CITY OF PORTLAND

Brain Knox
The Widewaters Group
145 Kingspine Boulevard
Portland, Maine 04102
CBL: 029AA016

11/13/2000

After a site visit and walkthrough on Monday, November 13, 2000, the following items of concern were brought to your attention at our meeting in your office trailer.

REVISIONS	
JOB NO.	0479.000
DRAWING TITLE	GUESTROOM PLANS & RISER DIAFRAM - ELECTRICAL
SHEET NO.	E3.01

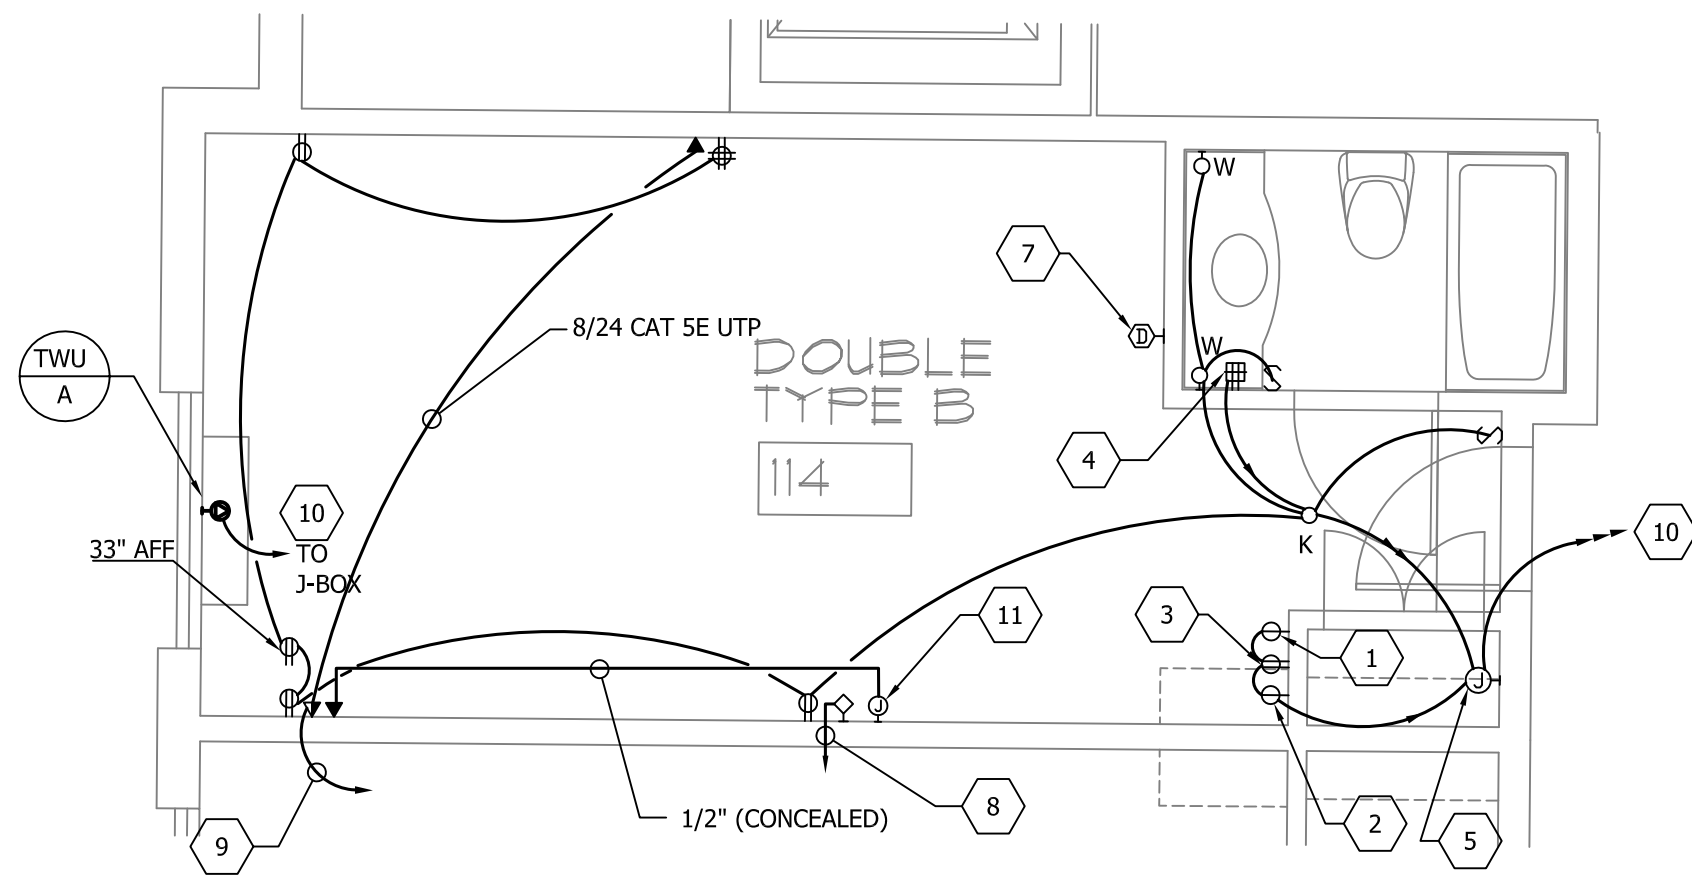
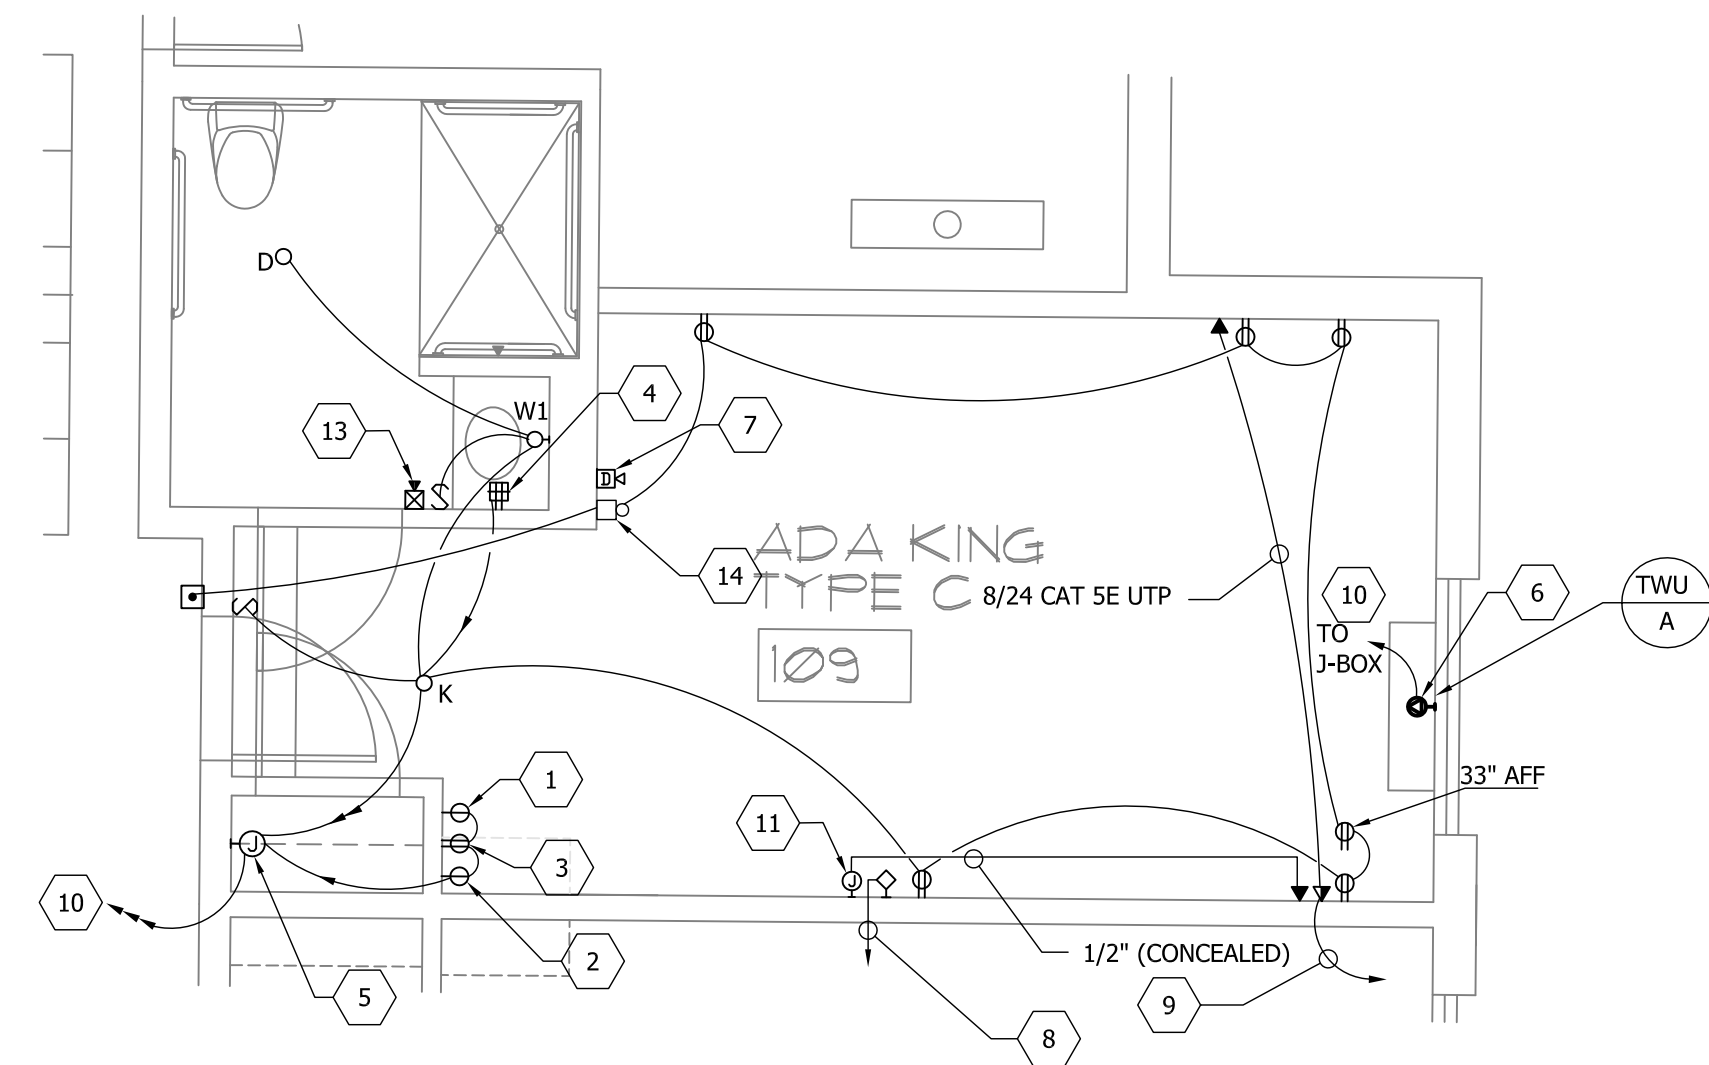
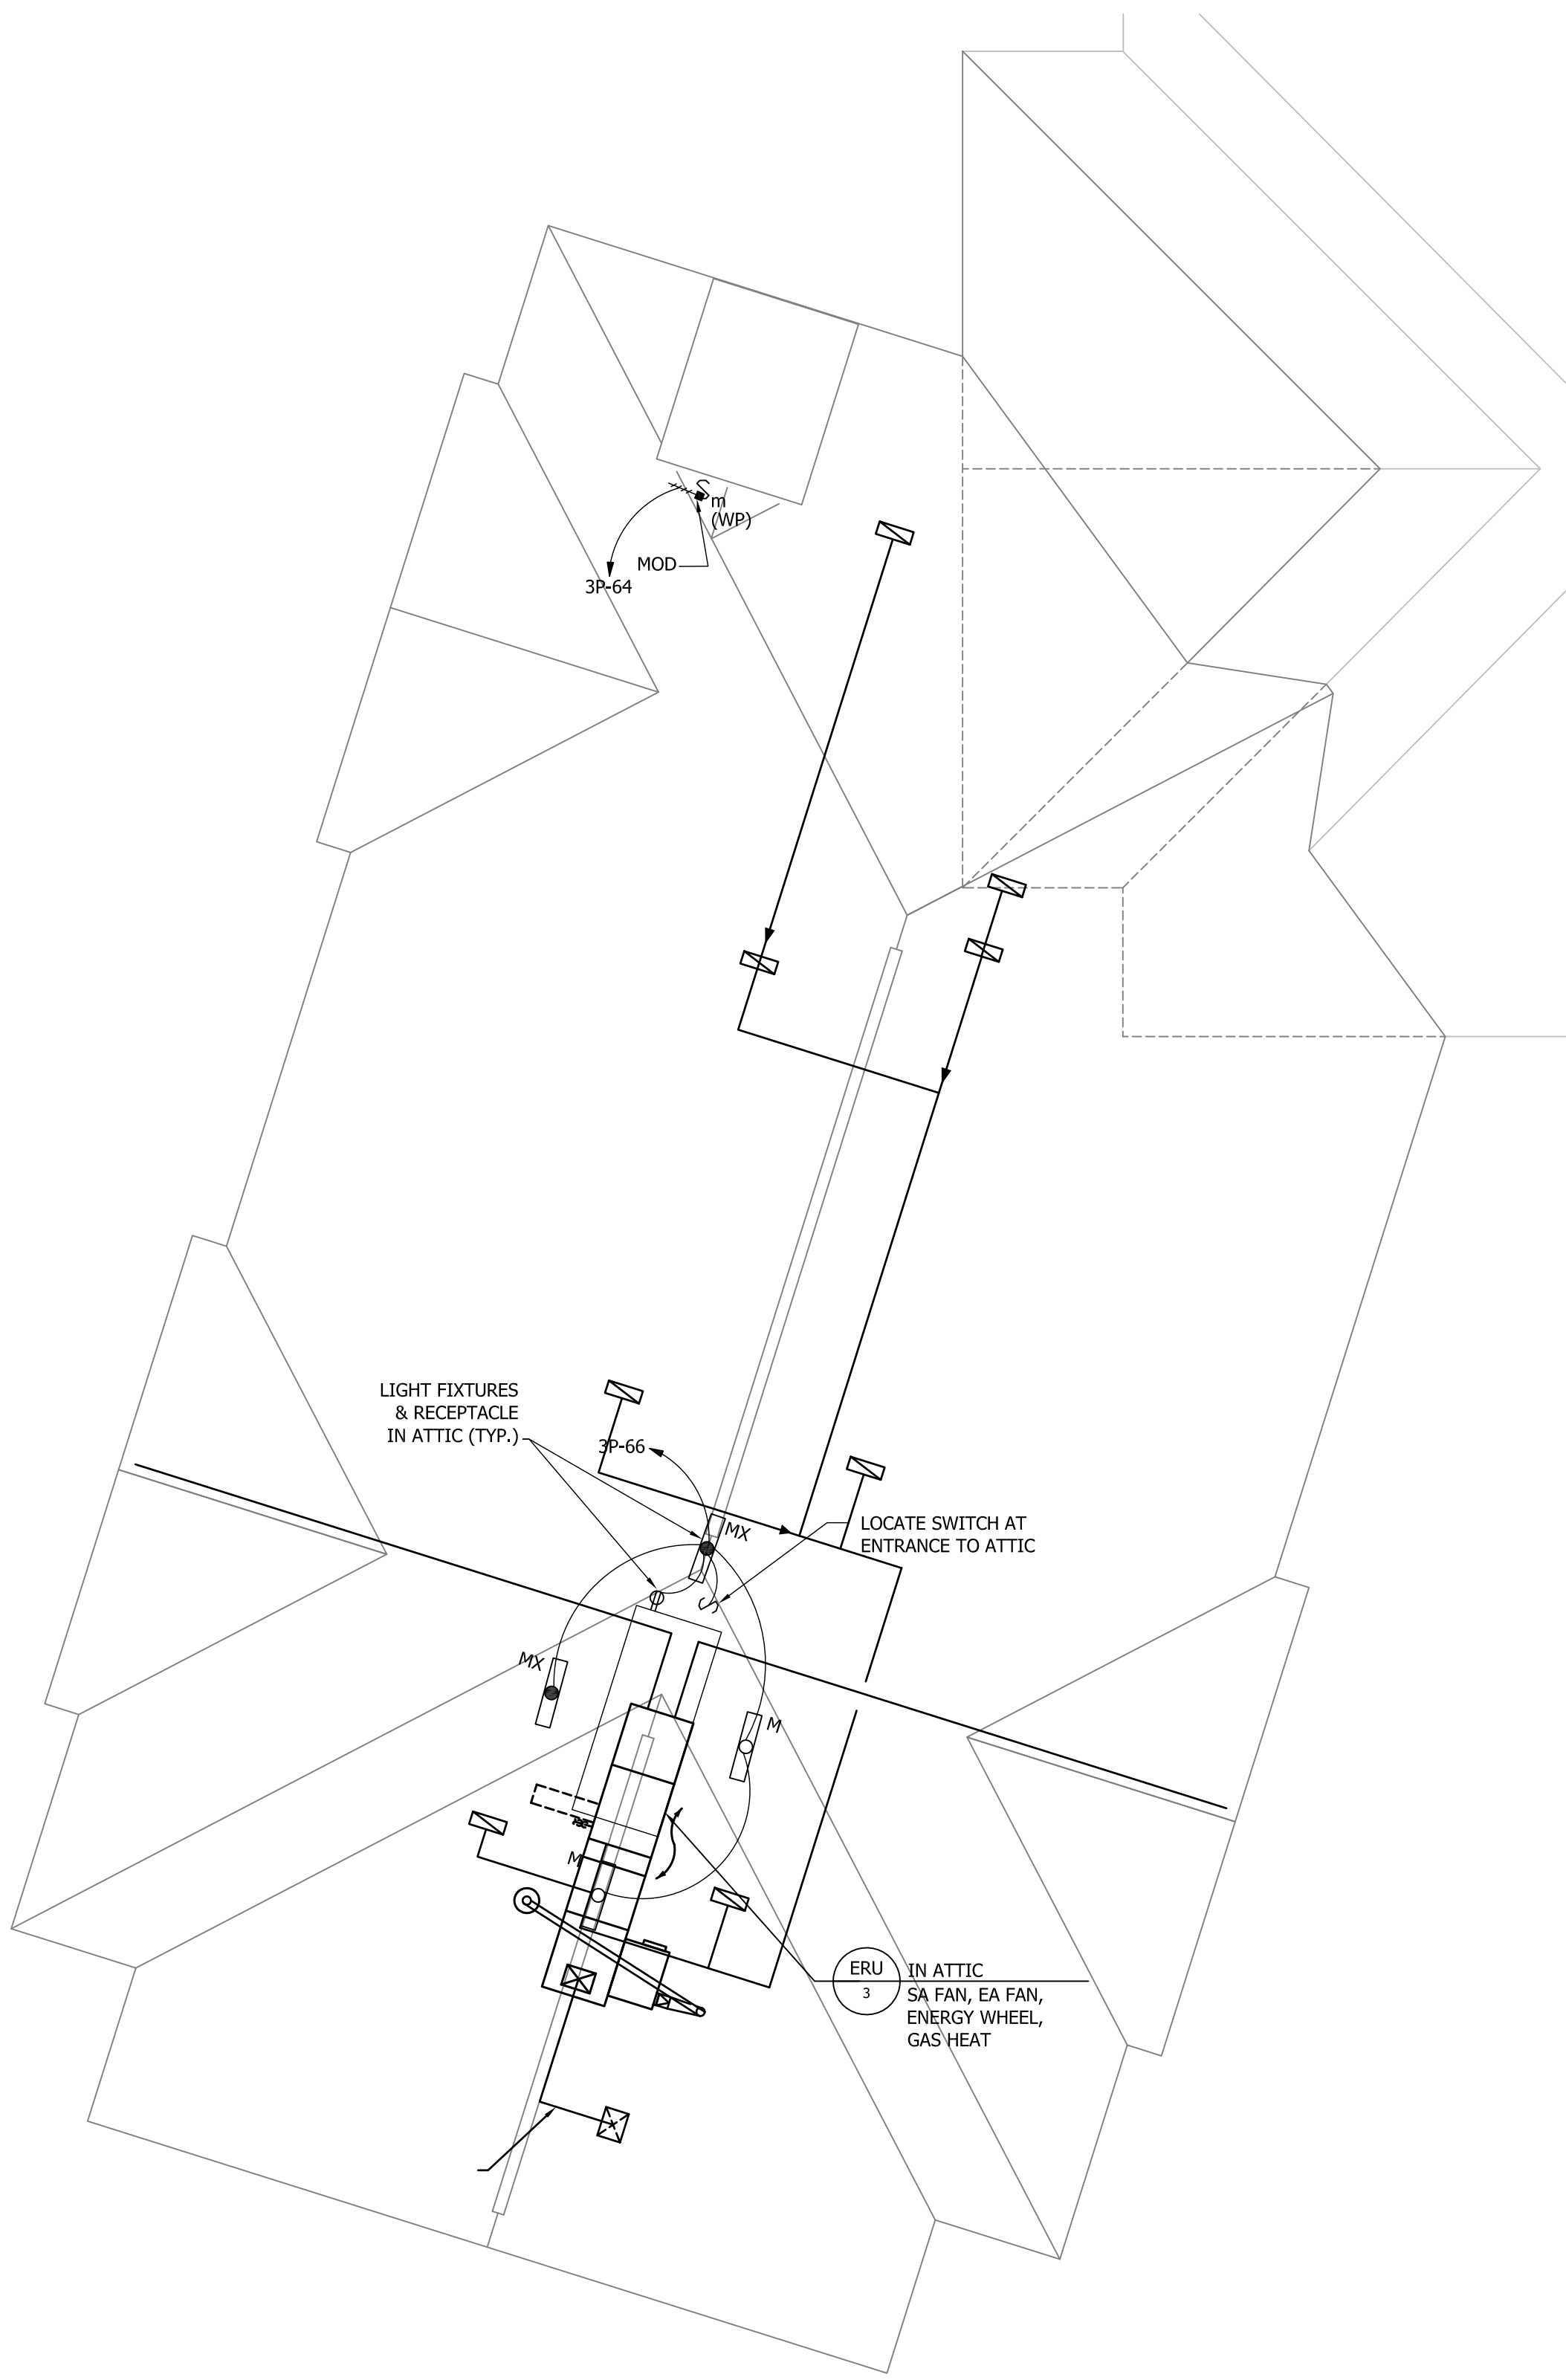
- All guest rooms shall have at least two receptacle outlets readily accessible to any occupants of each guest room pursuant to NEC 1999, ART: 210-60(a) & (b).
- A reasonable working temperature at or about 45-50 degrees shall be maintained prior to and during installation of all wiring types, including NMC, MC and single conductors and cables, to prevent damage to the insulation of the cables or conductors, pursuant to NEC 1999, ART: 90-1 & ART: 110-11.
